DARLING
HARBOUR LIVE
THE SOUTHERN
PRECINCT
SUPPLEMENTARY
DESIGN REPORT
FOR SSDA5

February 2014

This report has been prepared by Denton Corker Marshall in response to the DoPI letter dated 28 November 2013 and addendum. It also addresses the relevant issues raised by the City of Sydney submission to SSDA5. It provides additional clarification and/or response to particular design issues. A full assessment against all of the conditions in Stage 1 DA approval has been prepared as a separate Appendix to the response to submissions.

7428A SK_104
PLANNING AMENDMENT P 8
1:600 @ A3 11/02/2014
Sign: [Signature] Date: 28 May 13

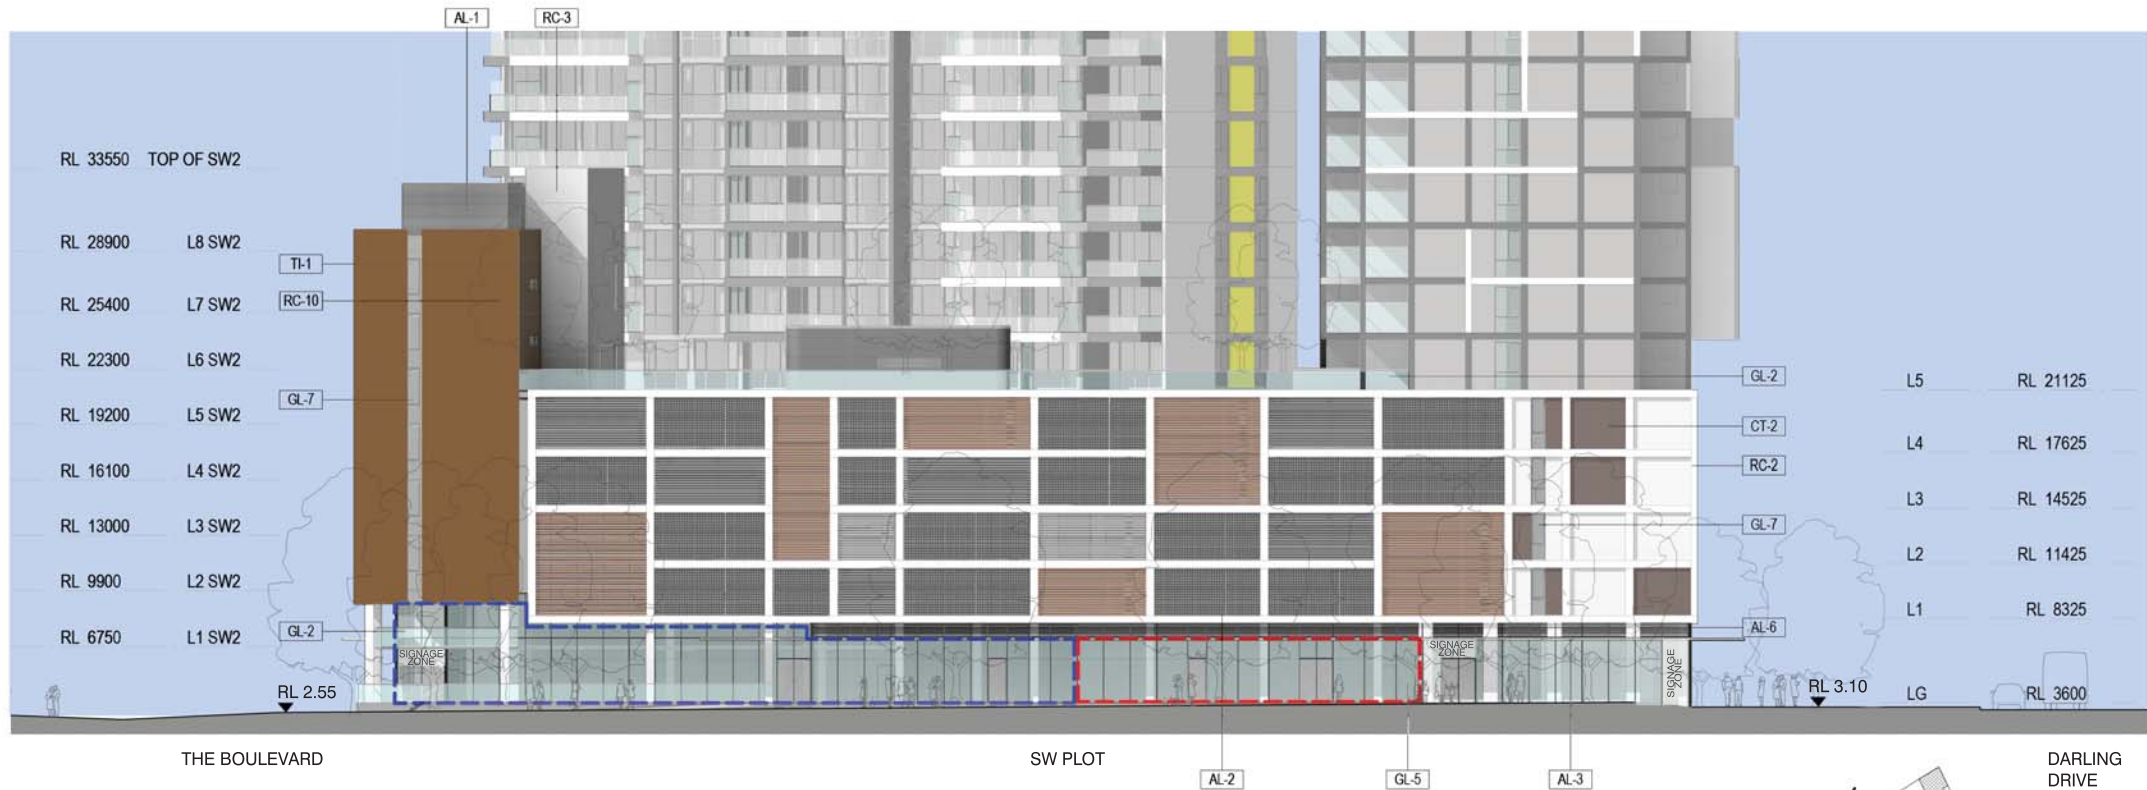
In the interest of achieving architectural excellence, the Department requires further consideration of the approach to the overall architectural treatment and articulation of tower SW1. The Department is concerned that the form and rigorosity of the gridded facade treatment coupled with the upper termination of the tower contrasts poorly with the architecture of the other elements of the SW Plot and would be visually dominant within the surrounding area.

The Department considers that the cantilevered projecting bay should be removed and notes Council's concern in this regard

In response to the DoPI concerns a number of modifications have been made to SW1. The projecting bay has been reconsidered and design improvements have been added to the west elevation to improve articulation and architectural excellence. The plant room has been lowered to a single storey and the grid expression has been accentuated. In addition, a response has been provided with respect to the window expression.

In response to the department's concerns, the grid is reinterpreted and this bay is broken down into a series of cubes stacked atop one another.

A projecting square cowl, as an extrusion of the ordering grid, creates shadows and introduces an element of contrast defining each cube.

Similarly, the rooftop plant enclosure is simplified and expressed as another cube sitting on the roof (refer to page 11). This roof enclosure has been reduced in height by 2.55m.

7428A SK_112 P 9
PLANNING AMENDMENT 11/02/2014
1:300 @ A3
0 3 6 10M

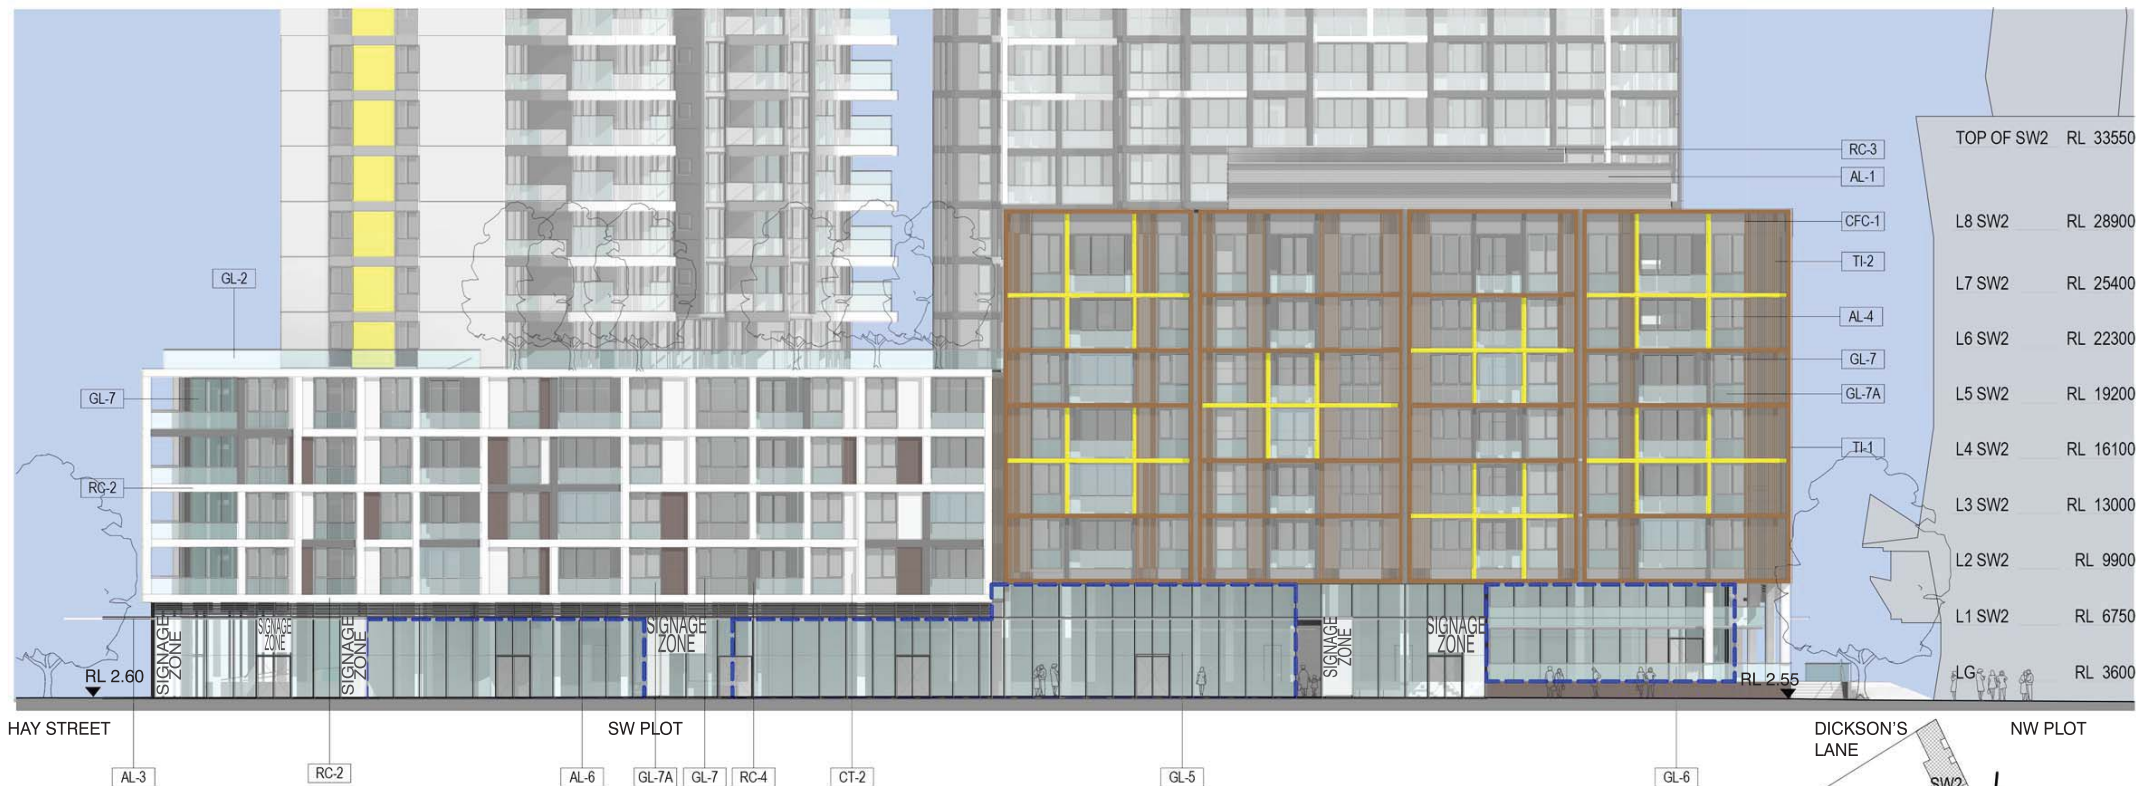
Future Development Applications shall maximise street level activation where possible. A Street Level Activation Plan shall be provided that:

- Increase activated frontage on Hay Street by locating new IQ hub (Potential)/ retail in lieu of services plant south of SW3 core; and
- Increased activated frontage on Darling Drive by locating new active uses north of SW1 core.

7428A SK-044
1:200 @ A3
0 2 4 6M

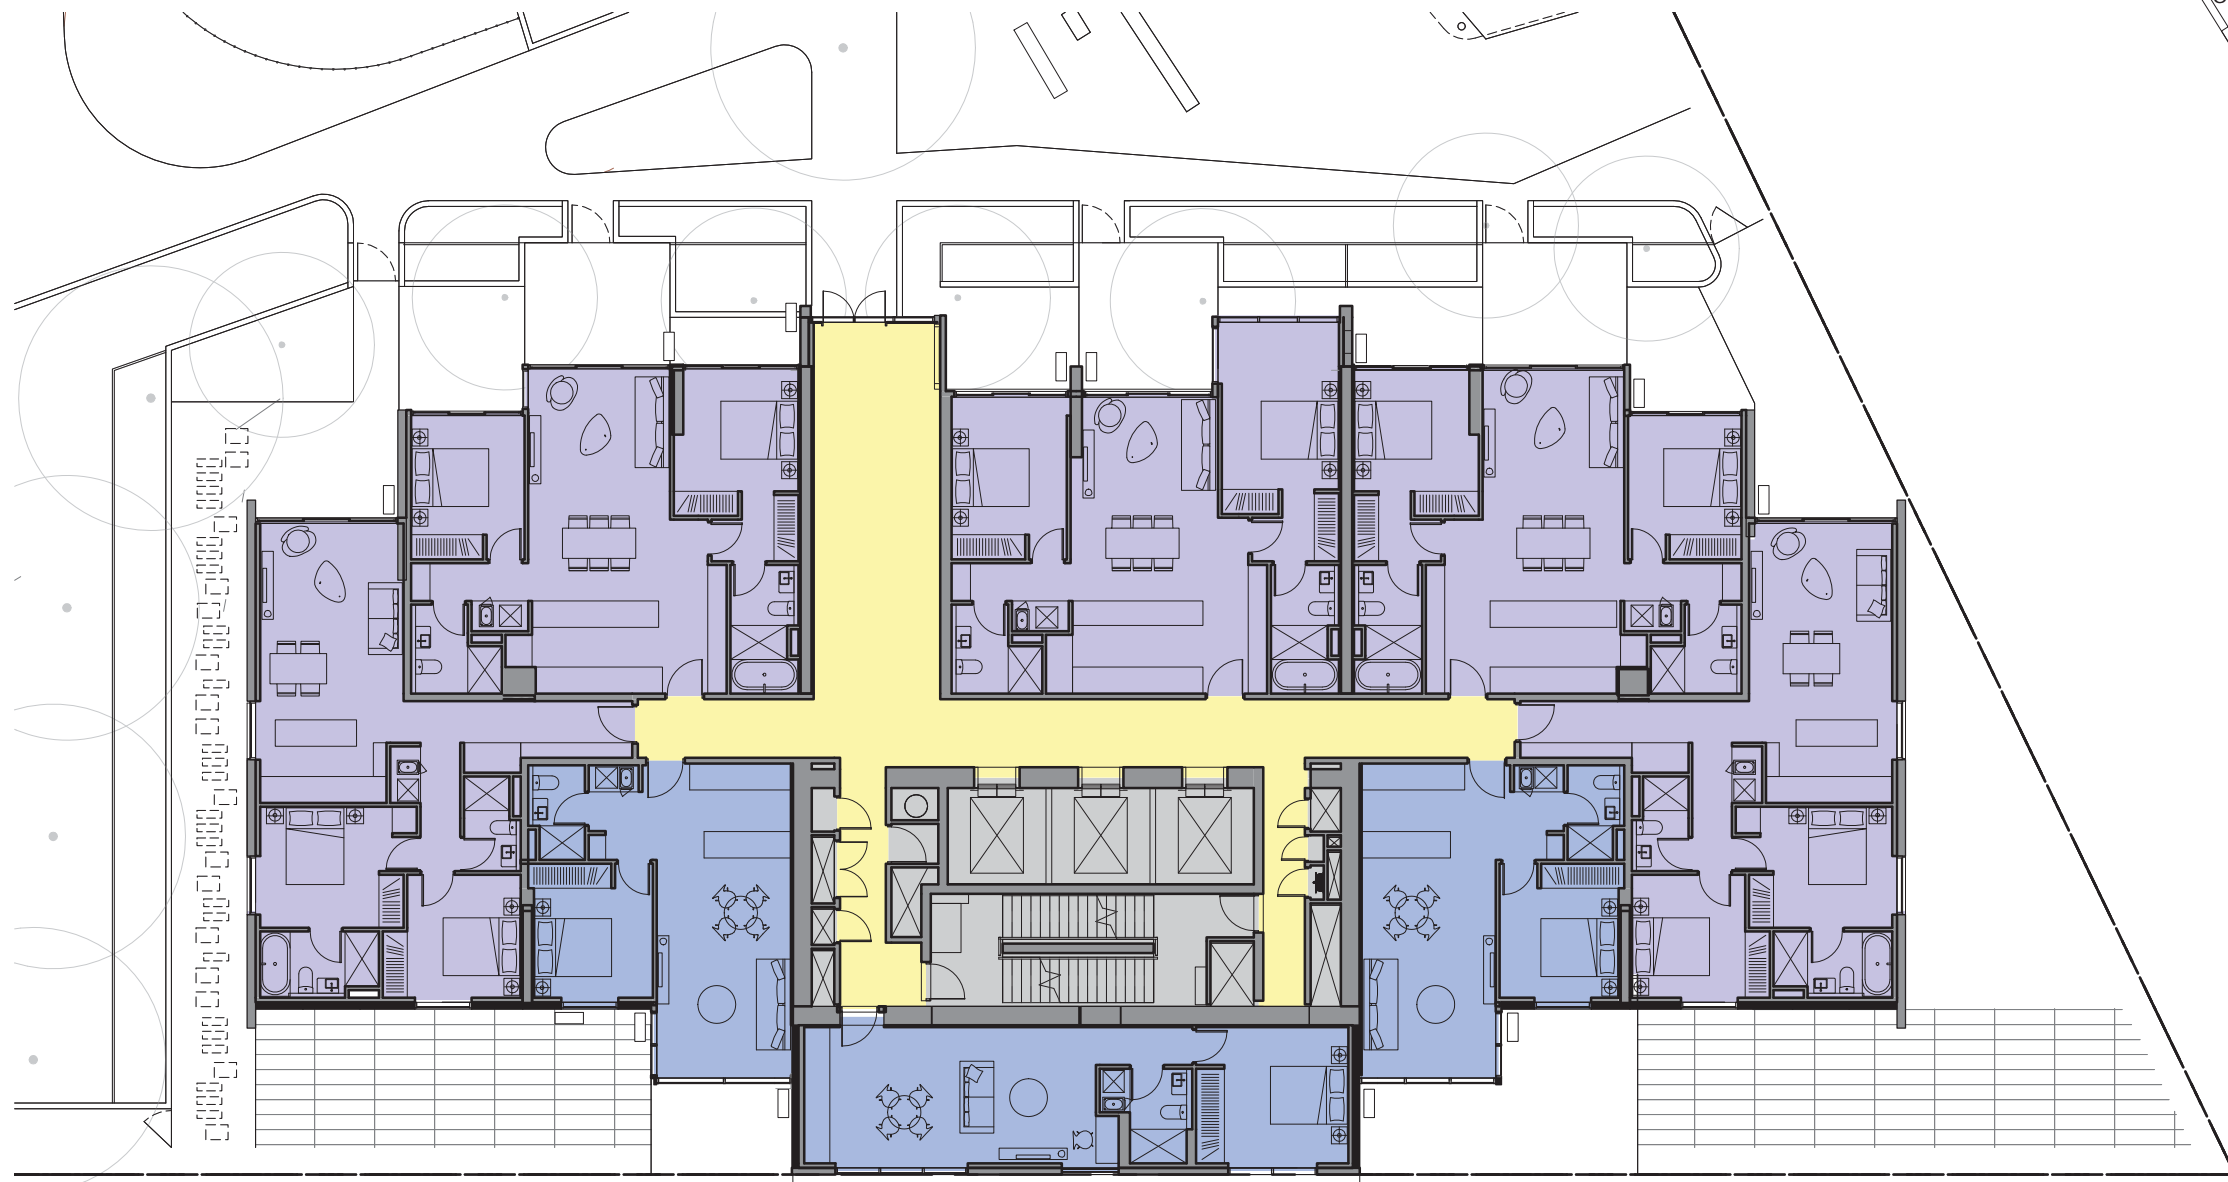
Further justification is required for the proposed mix of residential dwellings and the lack of larger 3 bedroom apartments.

- The number of 3 Bed units has been increased by 7 to 22 total. The additional 3 Bed units have been added to the podium levels increasing the product diversity of the development (refer to adjacent diagrams).
- The design of the 19 studios on the western elevation of SW1 have been reconsidered and improved. The product is now considered to be more aligned with the 1 Bed product in terms of the amenity afforded to residents. These have therefore been re-classified as 1 Bed (refer to pg.17).
- In addition, further product diversity is afforded by the provision of 10 apartments nominated as adaptable. The adaptable apartments will include a mix of 1 Bed and 2 Bed apartments and each will be allocated an accessible car space.

Extract from SK_044 SSDA5 showing 2 Bed unit (outlined in red).

Extract from Amended SK_044 showing 3 Bed unit (outlined in red).
